WELWYN HATFIELD COUNCIL – DEVELOPMENT CONTROL
DELEGATED REPORT

APPLICATION No:	S6/2008/2224/MA
------------------------	------------------------

This application seeks full planning permission for change of use of land to C3 dwelling houses, extensions and conversion of barn to create six bed dwelling plus staff accommodation. Erection of four two storey dwellings comprising of; 1 x three bed, 1 x four bed, 2 x five bed dwellings and ancillary car parking and landscaping following demolition of existing buildings.

Drawing No 04
 SOUTH EAST
 ELEVATION

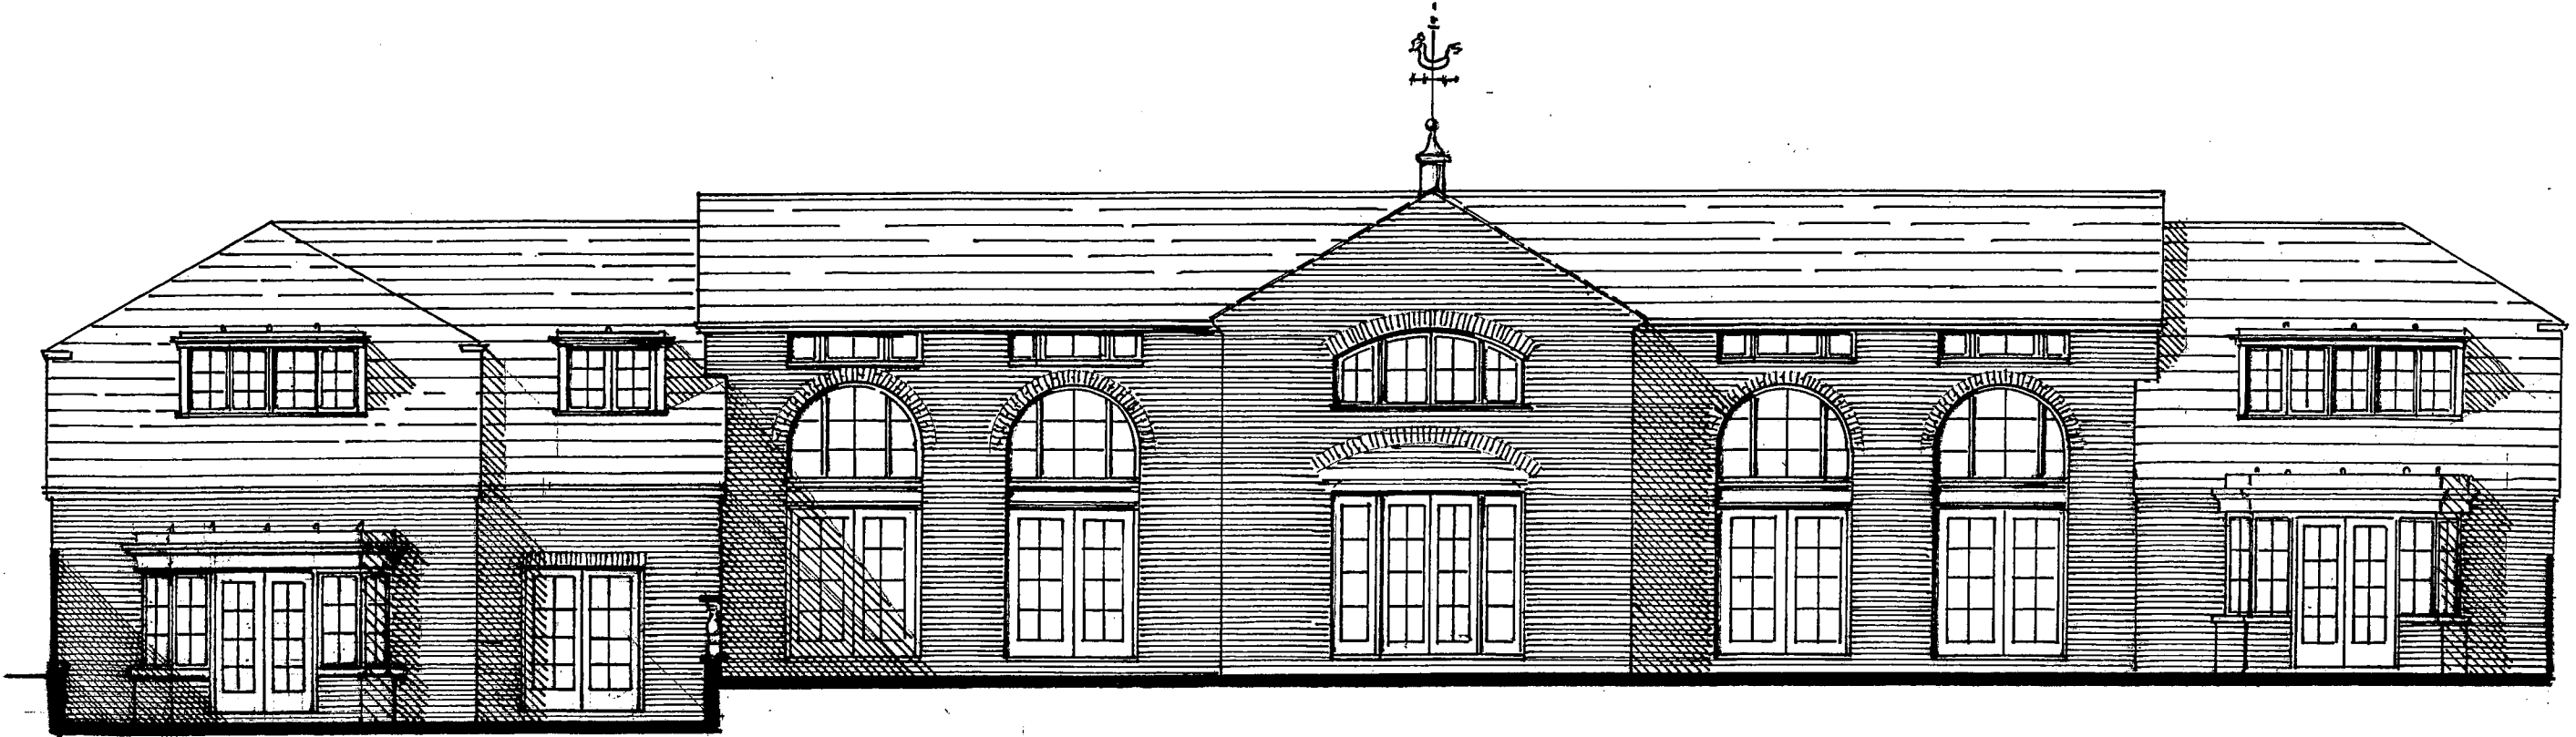
The proposed extensions to the large brick barn would result in a development that is not subordinate, comprising an approximate 75% increase in width and even greater increase in depth. However, as the scheme in relation to Green Belt policy is considered to be inappropriate it is not considered applicable to discuss this in great detail.

Drawing No. 01
 GROUND
 FLOOR PLAN

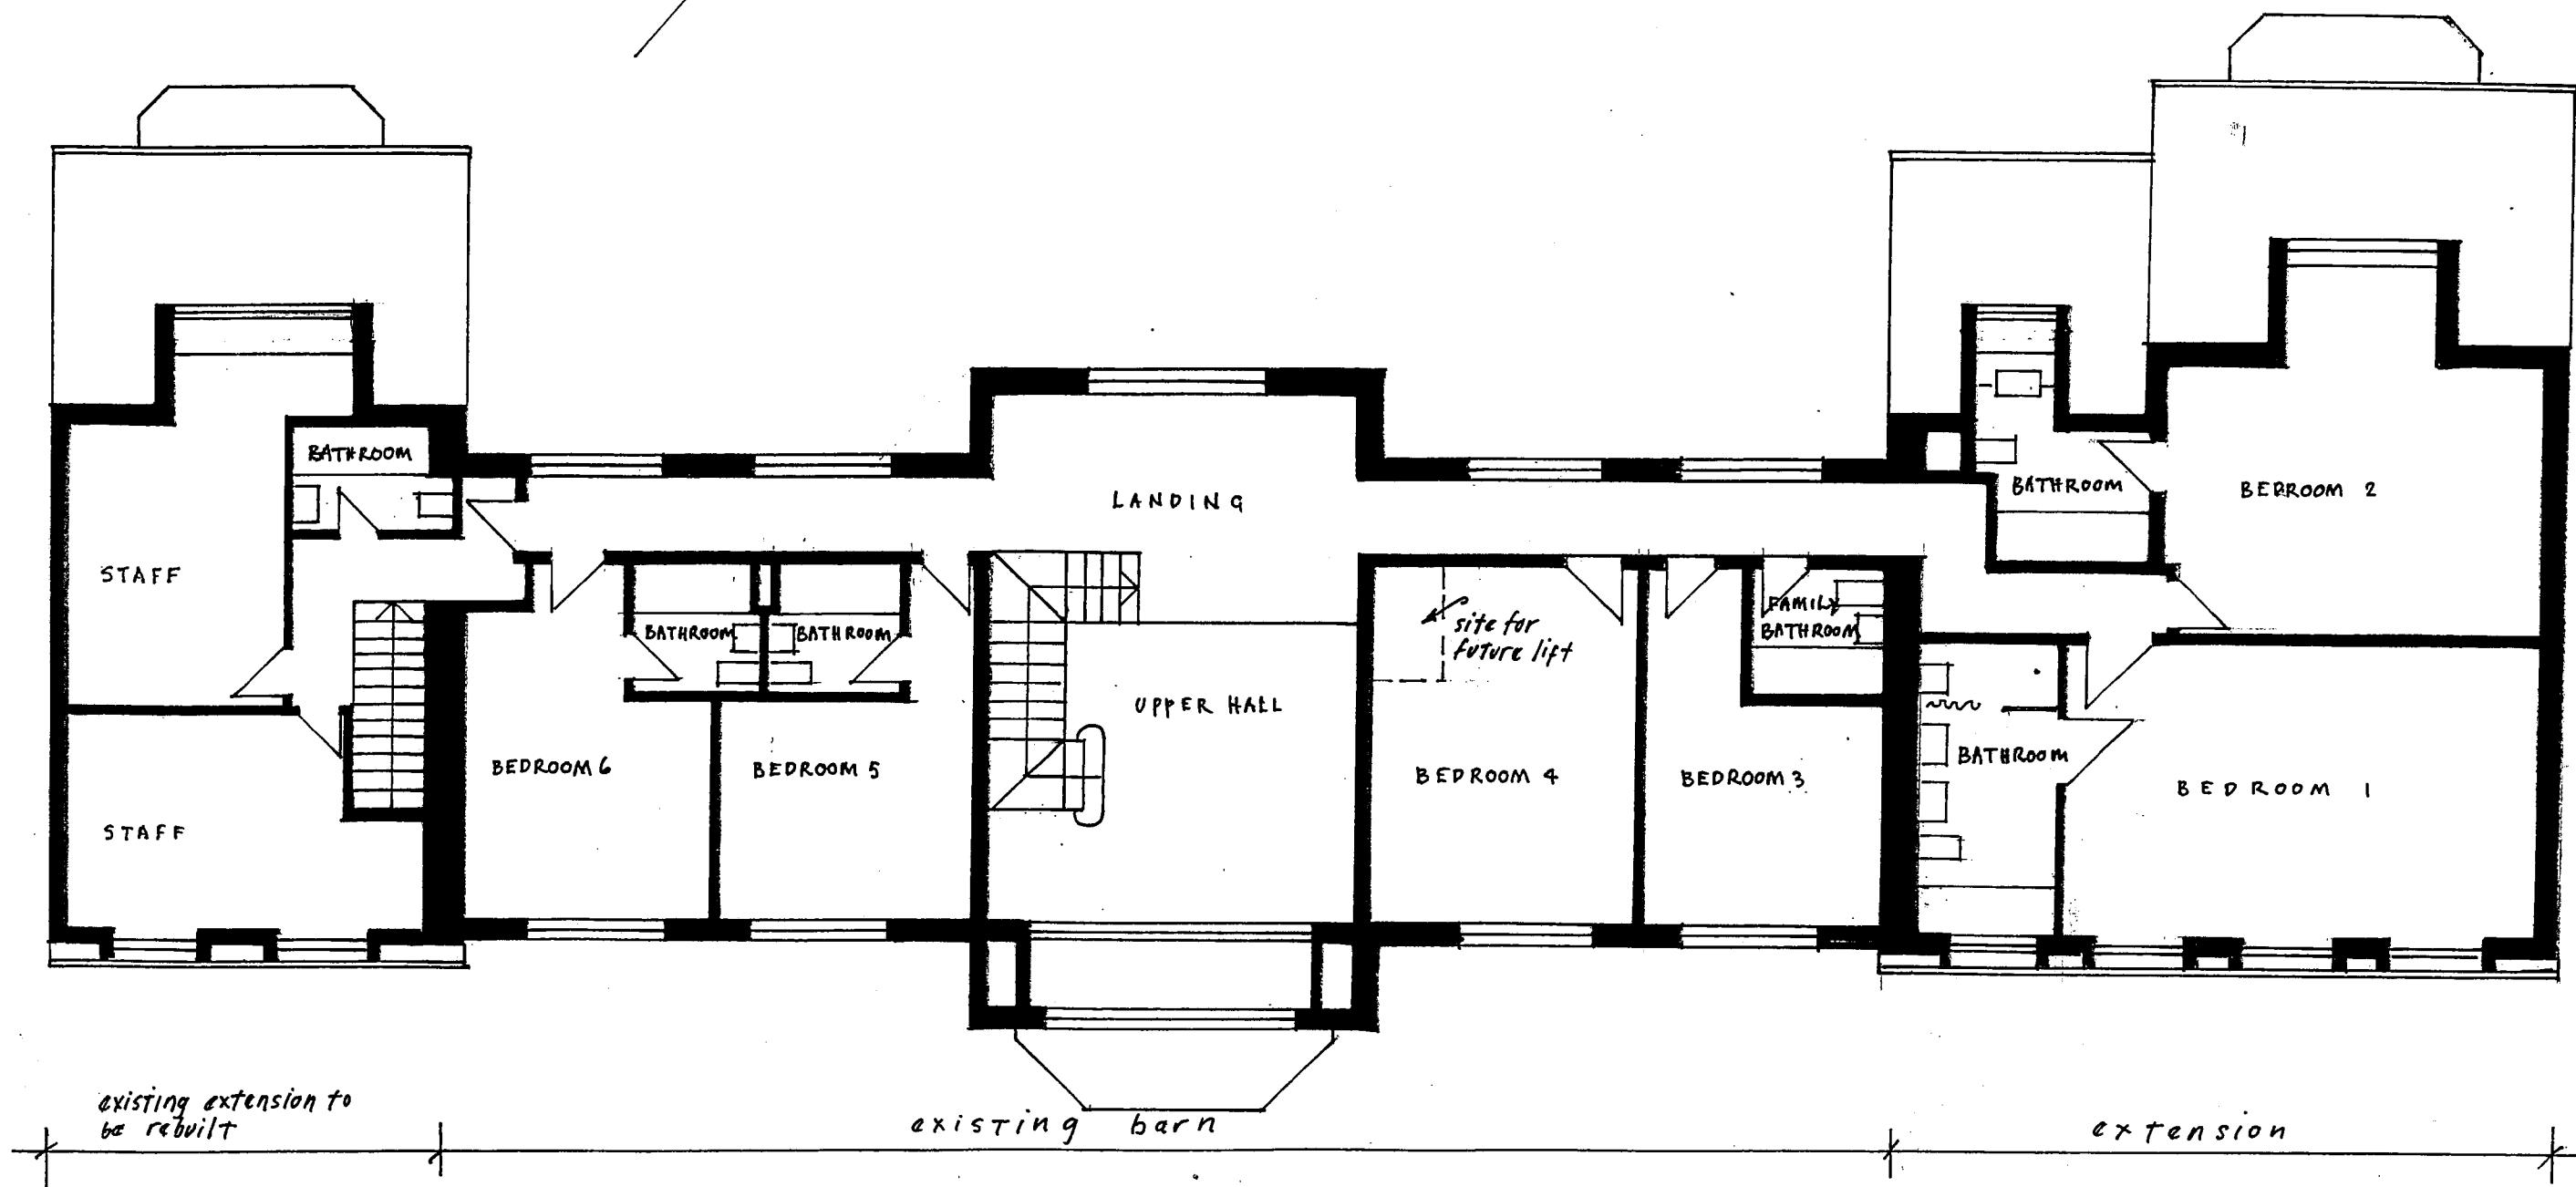
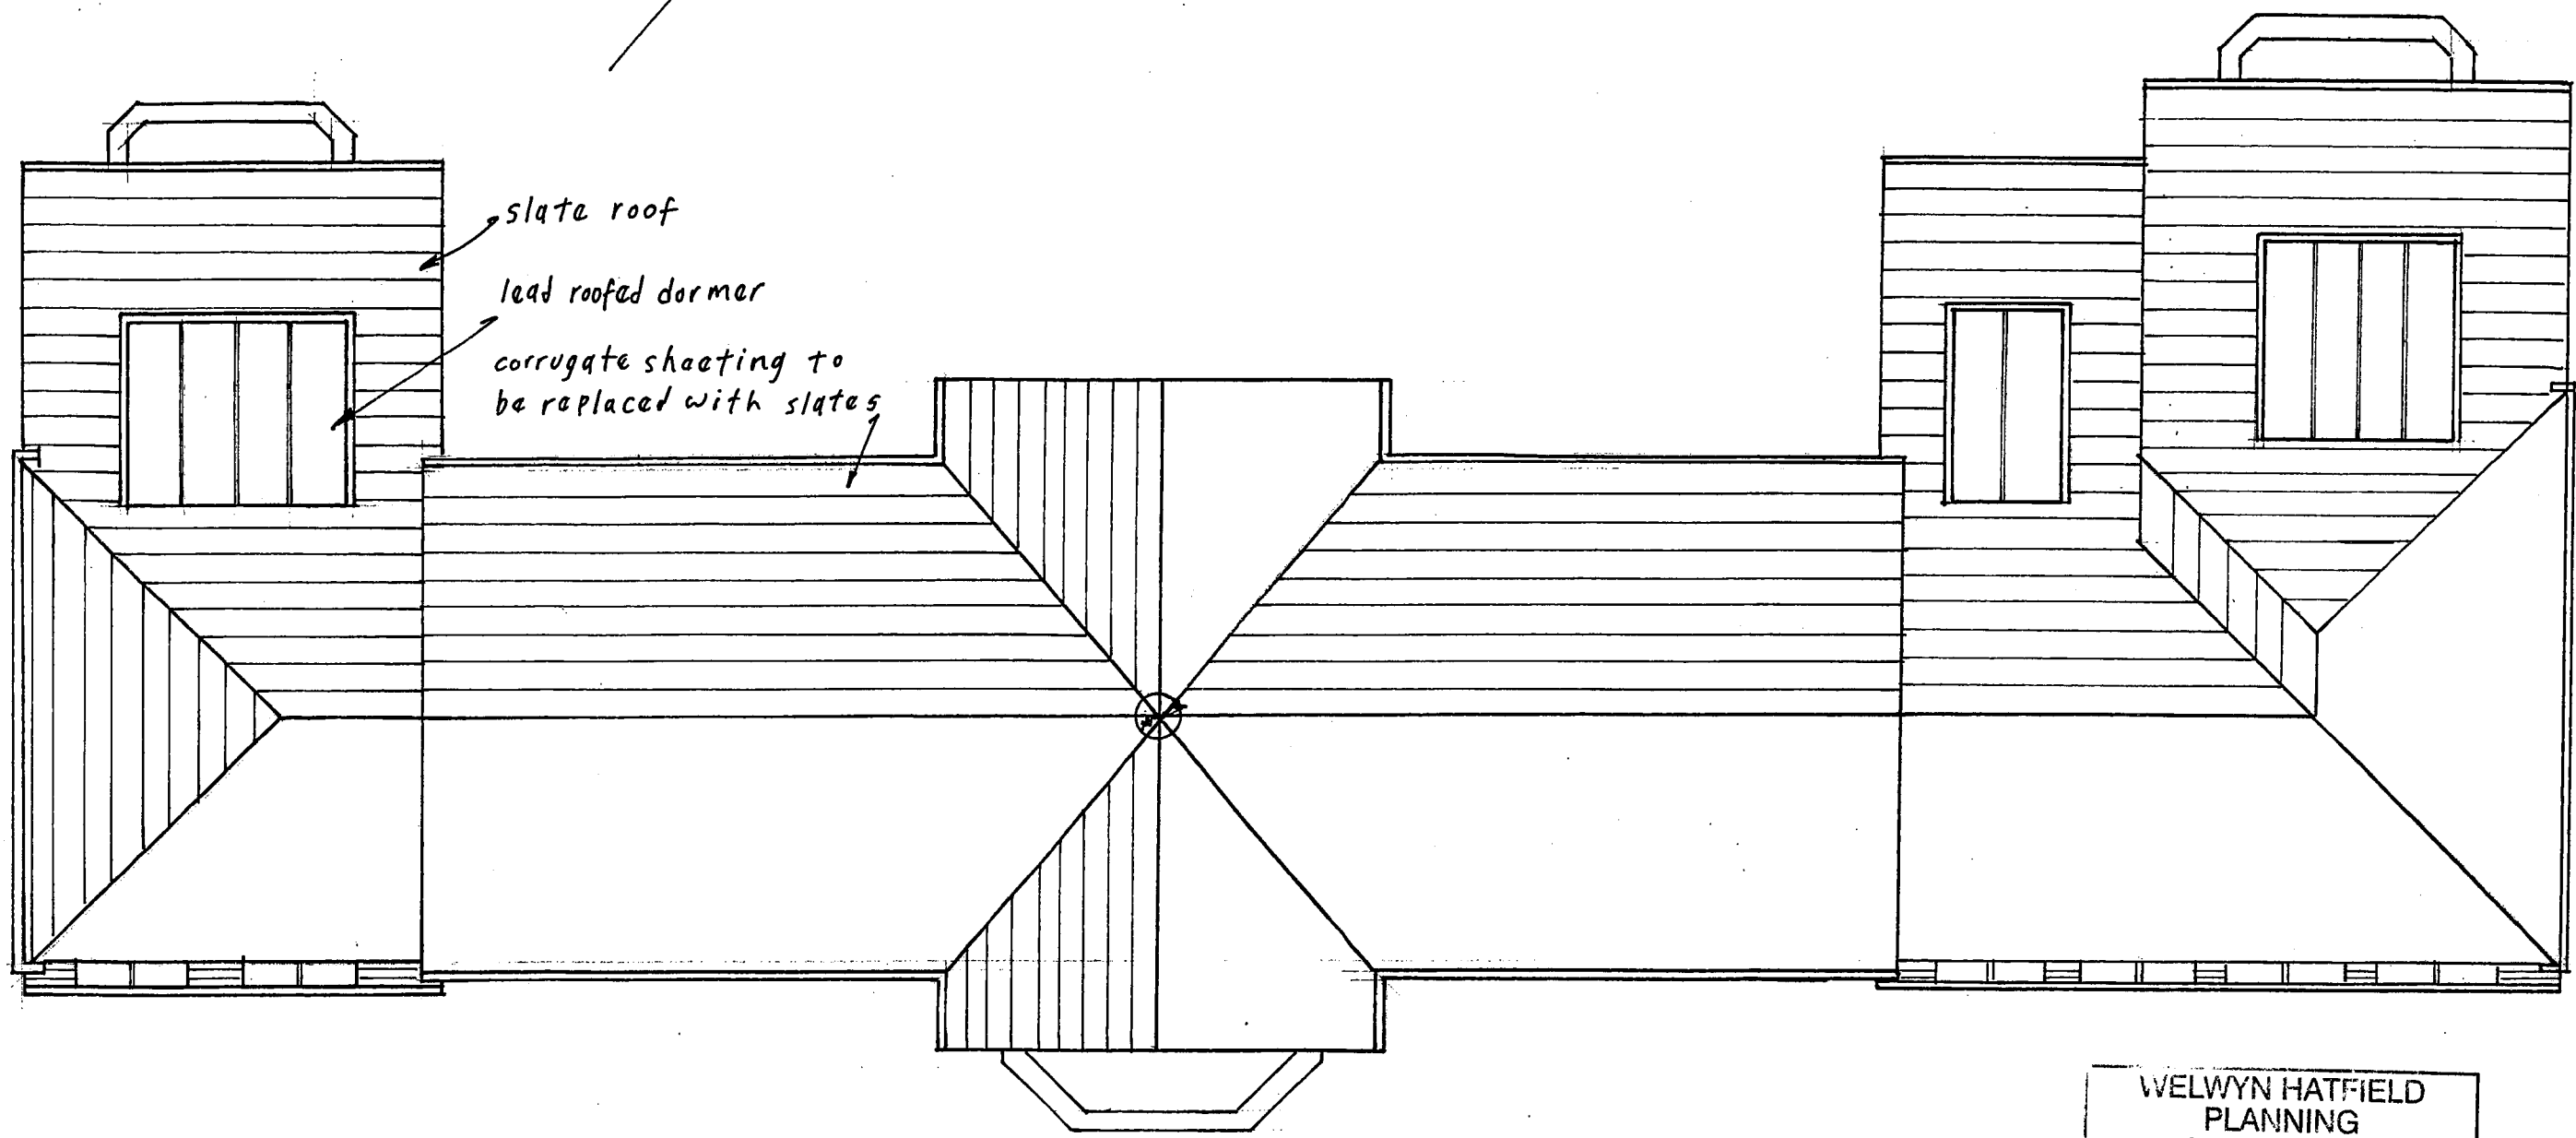
The proposed conversion of the large brick barn would be dependent on the erection of extensions that would substantially increase the footprint and floor space provided within the existing building. The proposed extensions would result in a 127 percent increase in the size of the footprint over the existing building. From this basis it is considered that the amount of extensions required to facilitate the conversion of the building are not in accordance with PPG2 or policy RA17 of the Welwyn Hatfield District Plan 2005 and therefore the proposed development is inappropriate within a Green Belt location. Furthermore, the proposed extensions would be of a scale and bulk that would make the extension unduly prominent at the application site and from the surrounding area, and would therefore have a significant impact on the

2. The proposed conversion of the brick barn is considered to be inappropriate within the Green Belt as it relies on significant extension to the existing built form that would detract from the openness character, appearance and visual amenity of the Green Belt. As such, the proposal represents inappropriate development and no very special circumstances have been demonstrated to exist to set aside Green Belt policies of restraint, and so is contrary to the advice contained in Planning Policy Guidance Note 2 and would conflict with the requirements of Policy RA17 of the Welwyn Hatfield District Plan 2005.
